CR2016/005378
SF2015/185355
KAP

MITCHELL AVENUE (RR7766): SSD 7520, KURRI KURRI BATTERY RECYCLING FACILITY,
LOTS: 796 & 797 DP: 39877, 129 MITCHELL AVENUE, KURRI KURRI

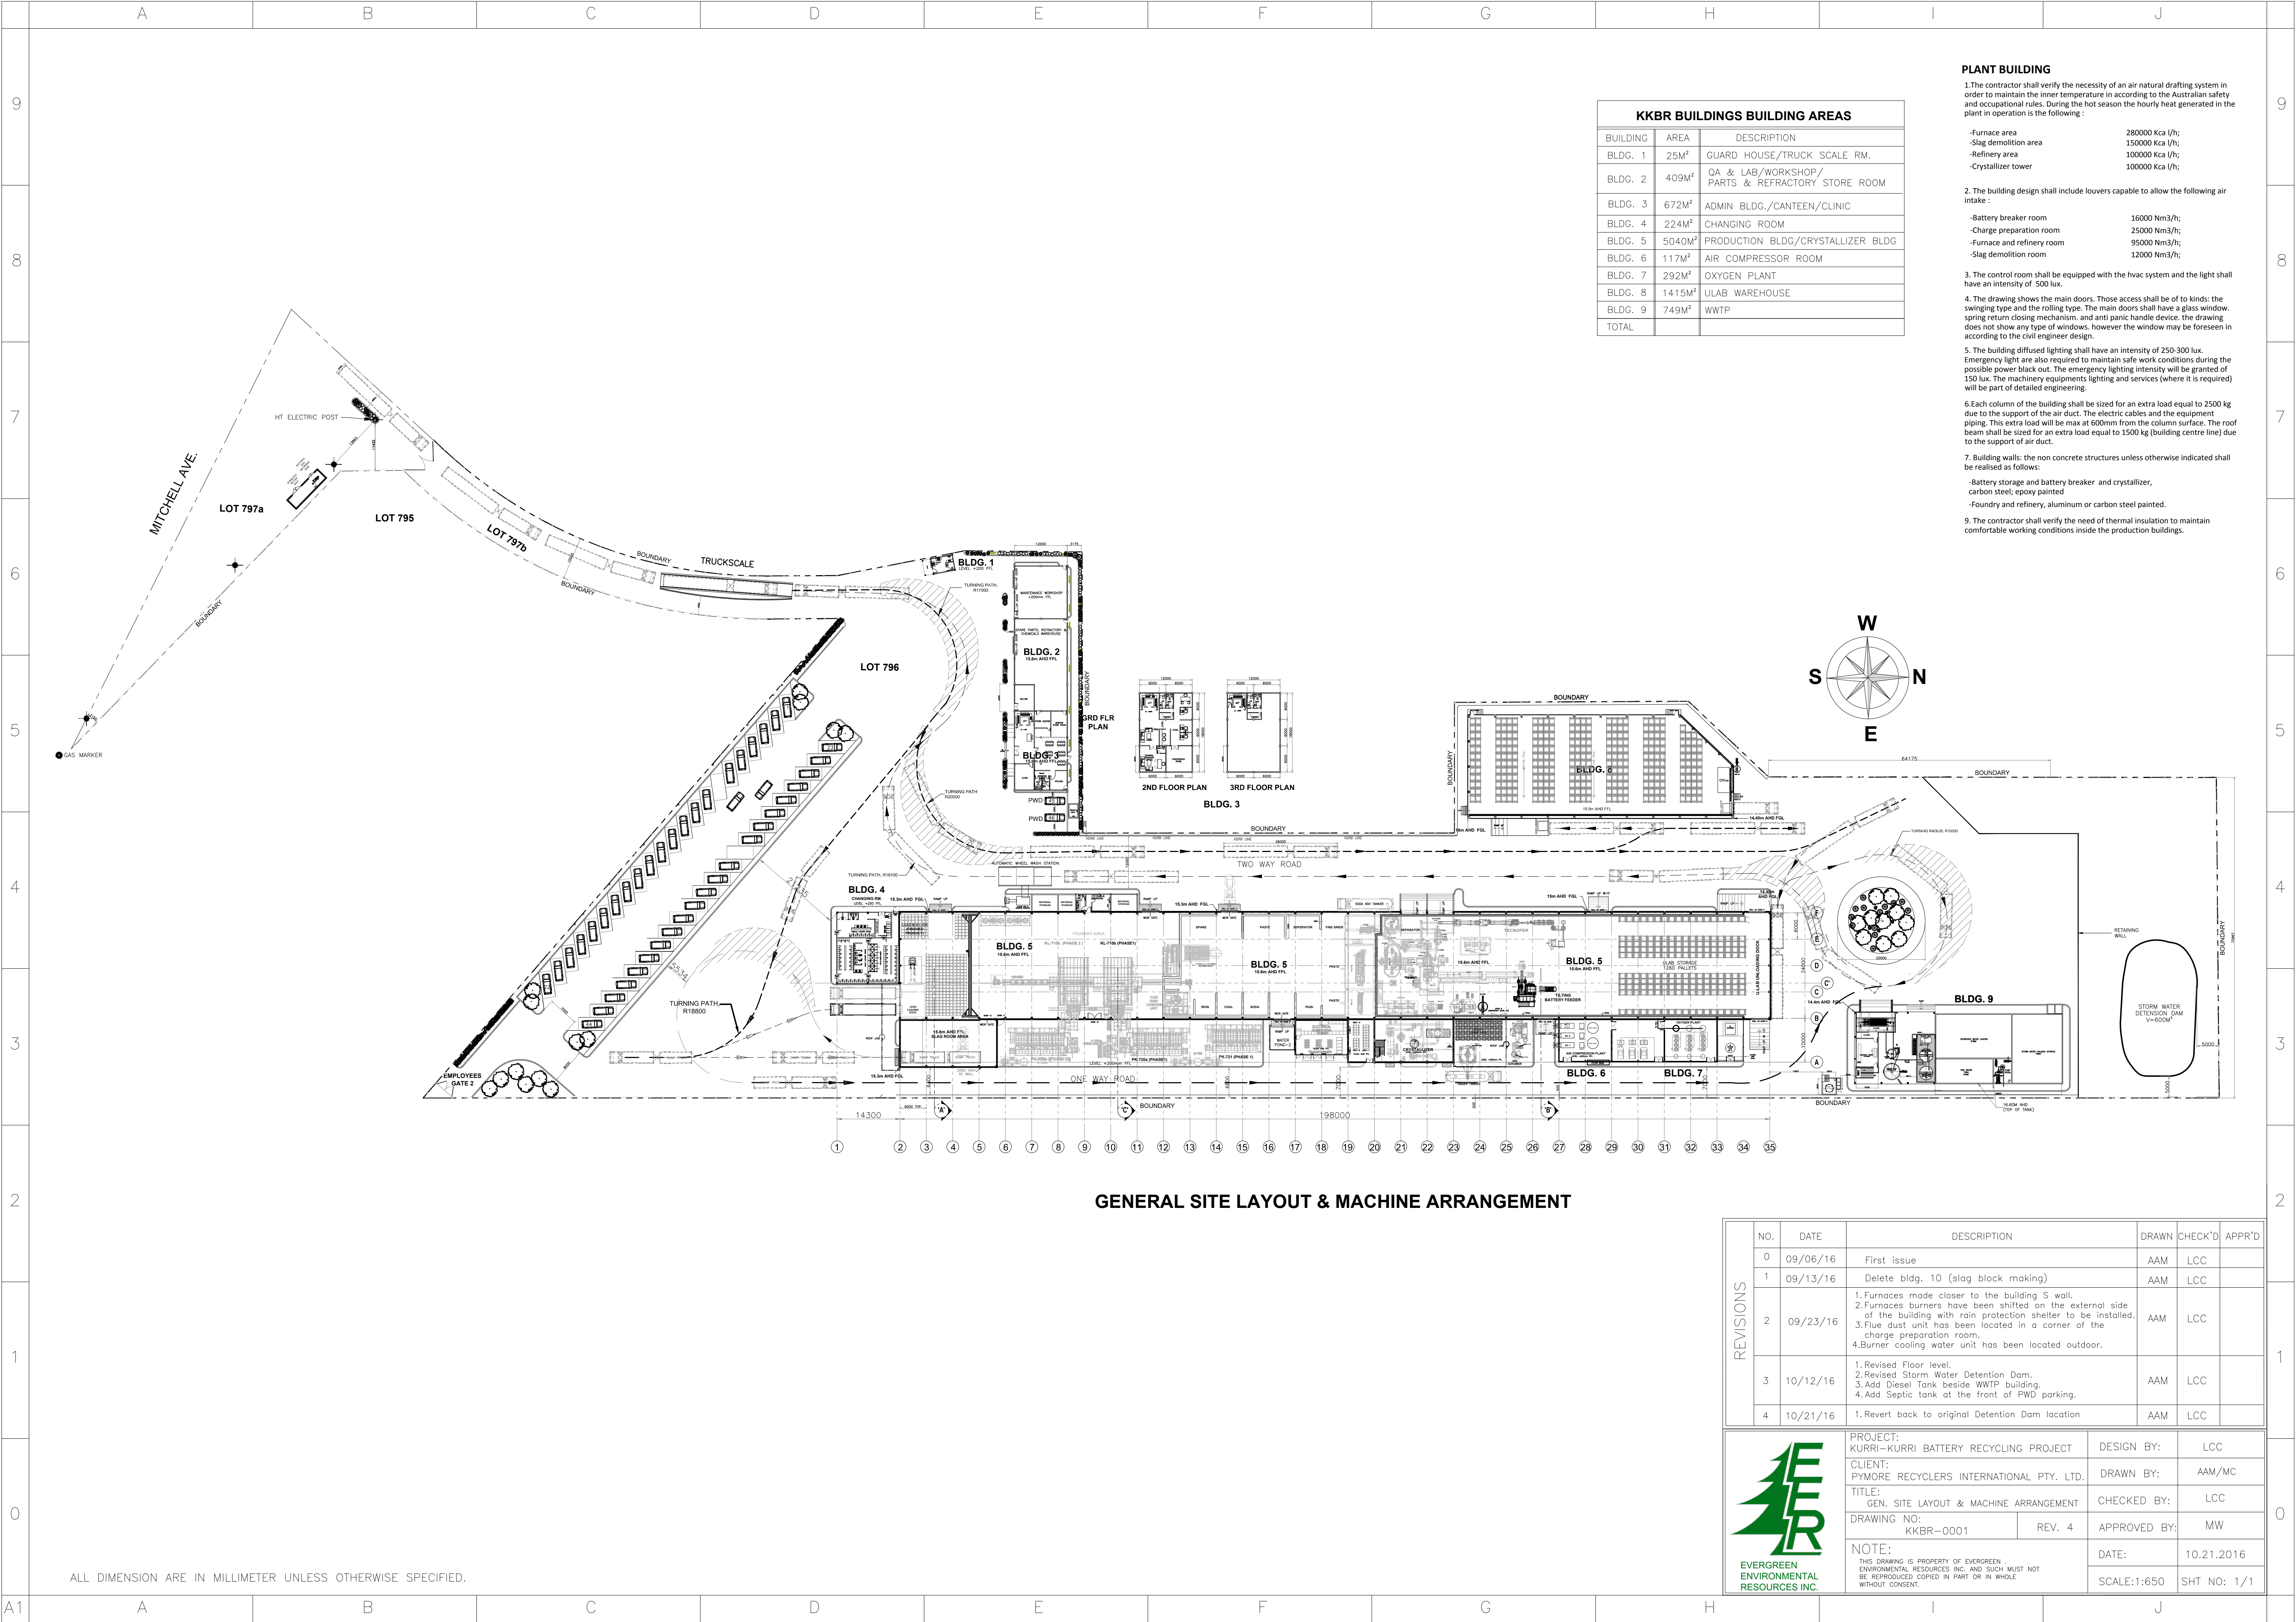
- DPE should ensure that an appropriate intersection design for the proposed new access is considered before development consent is issued. The location of the access is in close proximity to the existing intersection of Johnson Avenue and traffic counts within the traffic assessment revealed that this intersection is used by a high percentage of heavy vehicles. Any future new access to the subject battery recycling development should ensure that it is capable of accommodating the design vehicle and that the existing intersection into Johnson Avenue is not compromised for use by heavy vehicles (including semi-trailers). It is noted that any intersection upgrade will be required to be approved by Cessnock City Council as part of a s.138 application as Council is the roads authority for Mitchell Avenue and as such, it is recommended that DPE consult directly with Council about this matter. Consideration should be given to the provision of suitable intersection upgrade treatment consistent with the warrants in section 4.8 of *Austroads Guide to Road Design – Part 4A Unsignalised and Signalised Intersections*.

- Consideration should be given to ensure appropriate sight line distances are available at the entry / exit from the subject site, in accordance with the relevant Australian Standards (i.e. AS2890:1:2004). The consent authority should be satisfied that the location of the proposed driveway promotes safe vehicle movements.
